## **PLANNING APPEAL / OBSERVATION**

**Re:** Case number: 324258. Proposed Wind Farm Development comprising 16 Wind Turbines, Battery Storage Facilities, 110kV Substation, Grid Connection Infrastructure, Access Road Upgrades and Associated Works

PUBLIC ROAD WIDENING - DETAIL

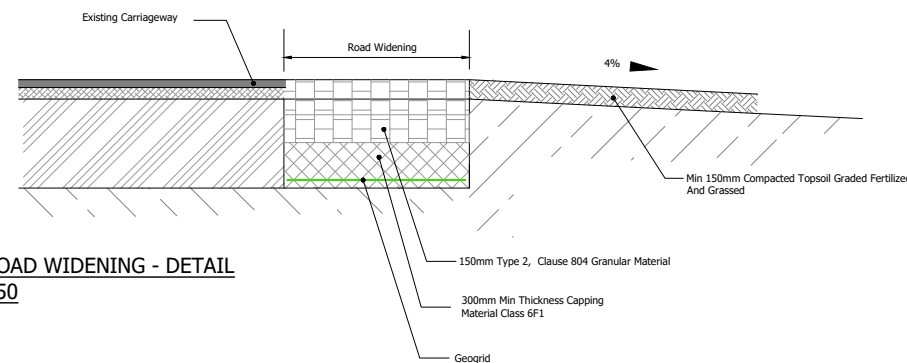
The proposal includes multiple new entrances, widening of local roads, and transportation of abnormal loads through extremely rural road networks.

The increase in heavy construction traffic will:

- Create hazards for disabled residents
- Increase journey times to essential care
- Affect accessibility for those of us with mobility impairments
- Reduce the safety of pedestrians and vulnerable road users like myself

Title
AUTOTRACK ANALYSIS
BALLINA TO SITE
PINCH POINT 11
(V117)

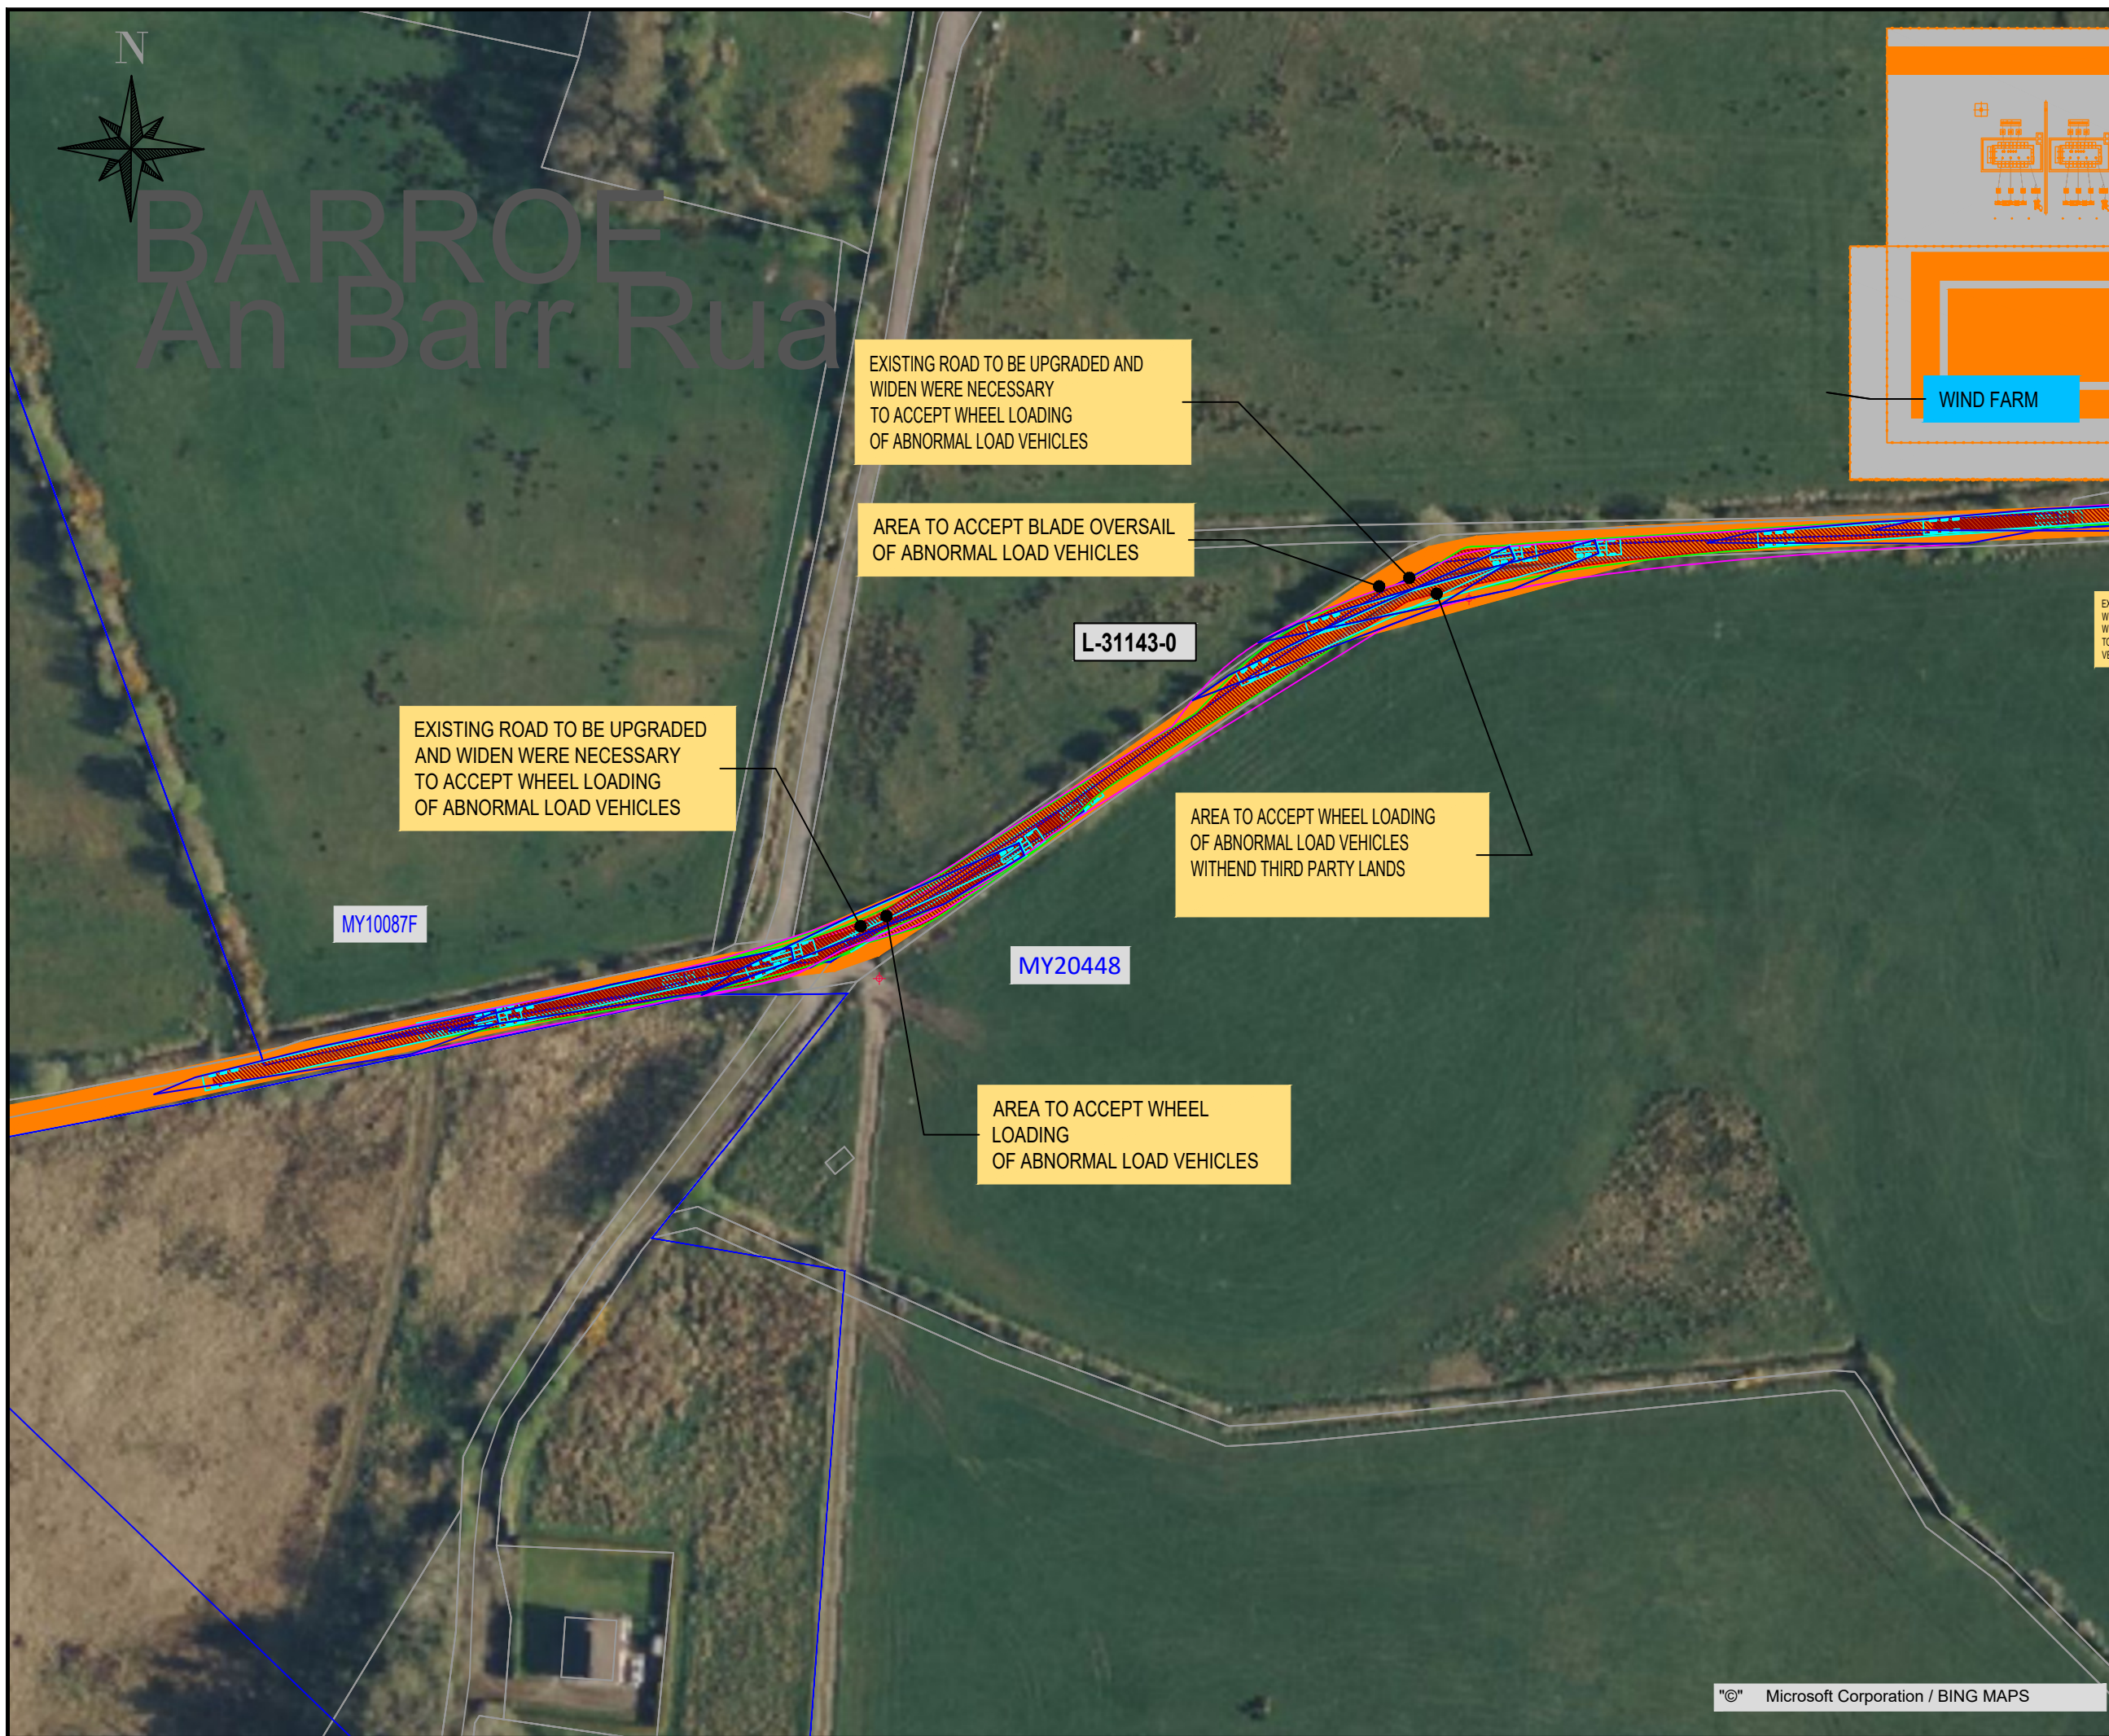
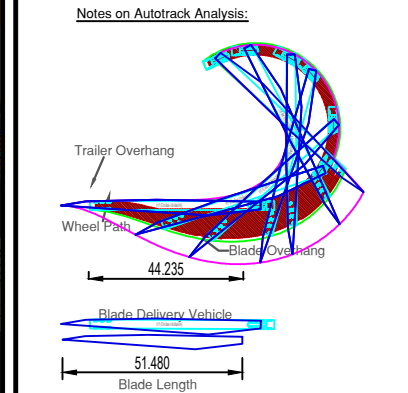
I am extremely concerned that the extensive road upgrades, widening works, abnormal load deliveries and construction traffic will create a significant disruption across local roads for a prolonged period.

The proposal identifies upgrades and alterations to numerous local roads and entrances. These works, together with the transportation of oversized turbine components, have the potential to:

- Cause temporary road closures and traffic restrictions
- Delay emergency vehicles responding to incidents
- Obstruct routes relied upon by ambulances
- Reduce road safety for vulnerable road users like myself.

Figure 12.3 ZTV indicating the cumulative theoretical visibility of the proposed Tirawley Wind Farm in combination with all other wind farms in the study area

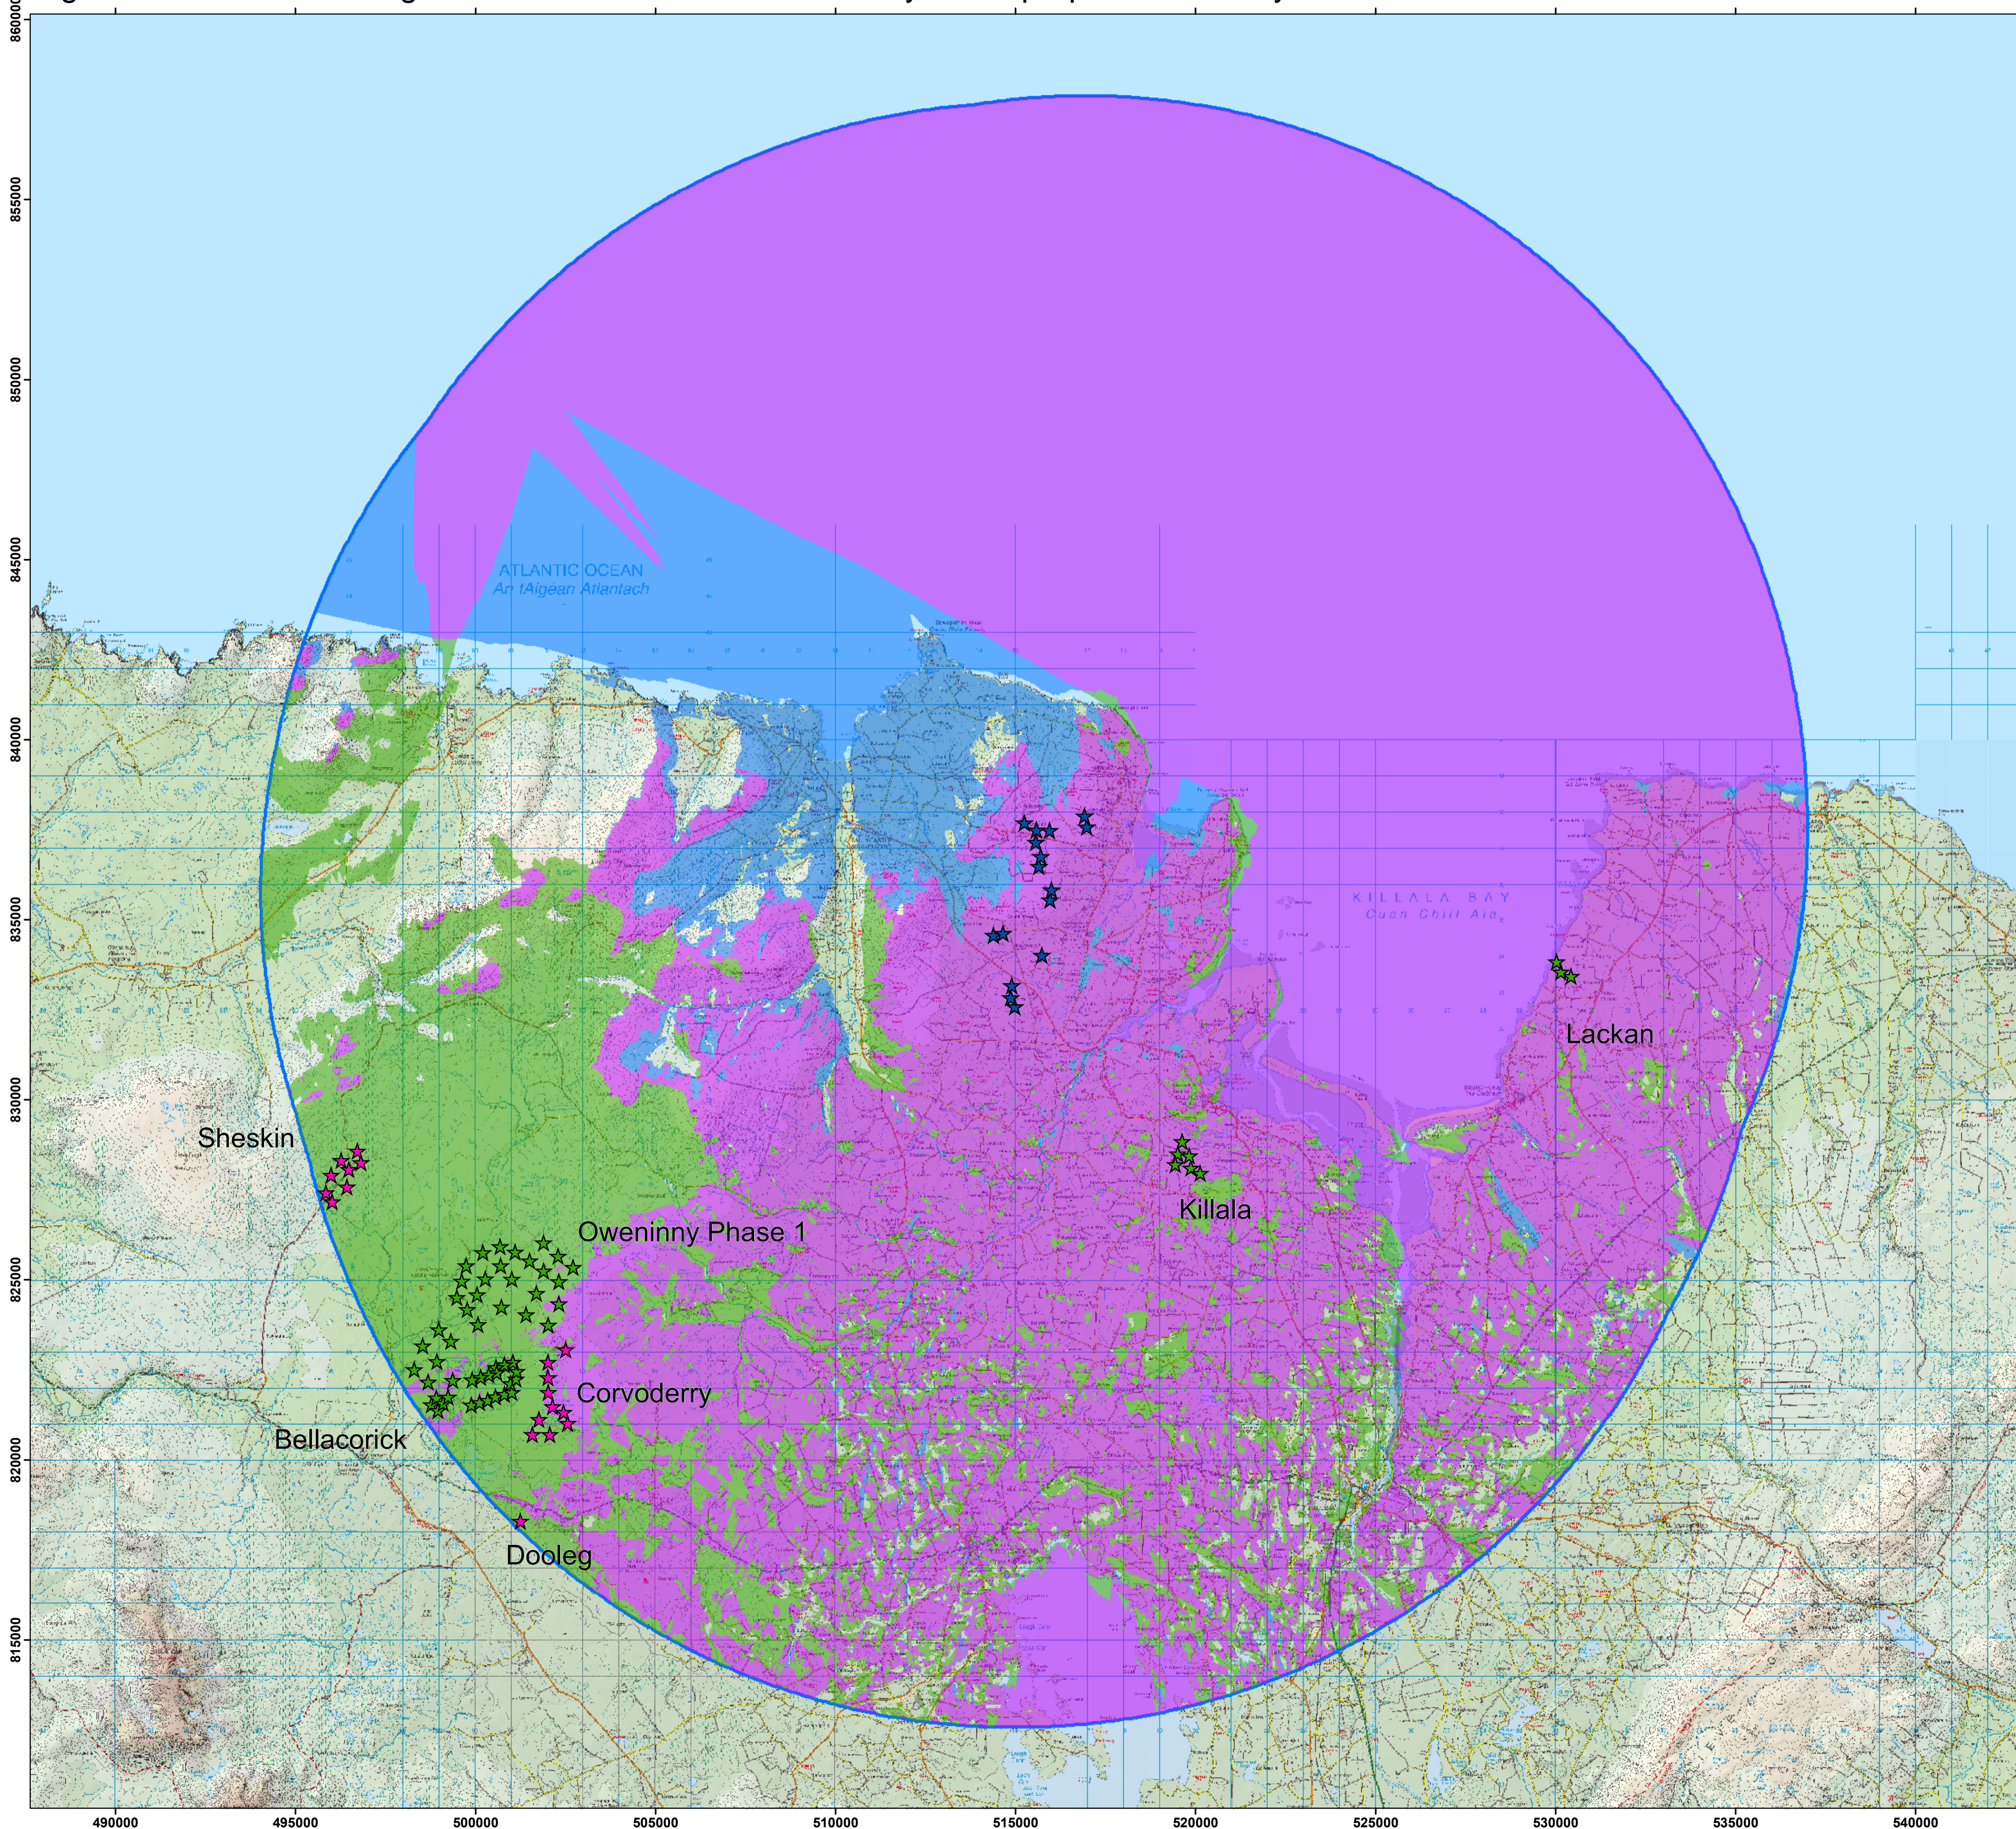
While individual elements of the project may appear manageable in isolation, the cumulative impact of:

- Wind turbines
- Battery storage facilities
- Forestry clearance
- Construction compounds
- Roadworks
- Grid connection infrastructure
- Heavy vehicle traffic
- Noise and visual impacts

creates a development of industrial scale in an unsuitable rural environment.

The cumulative burden placed on residents, particularly those of us with disabilities, has not been sufficiently recognised, addressed or mitigated.
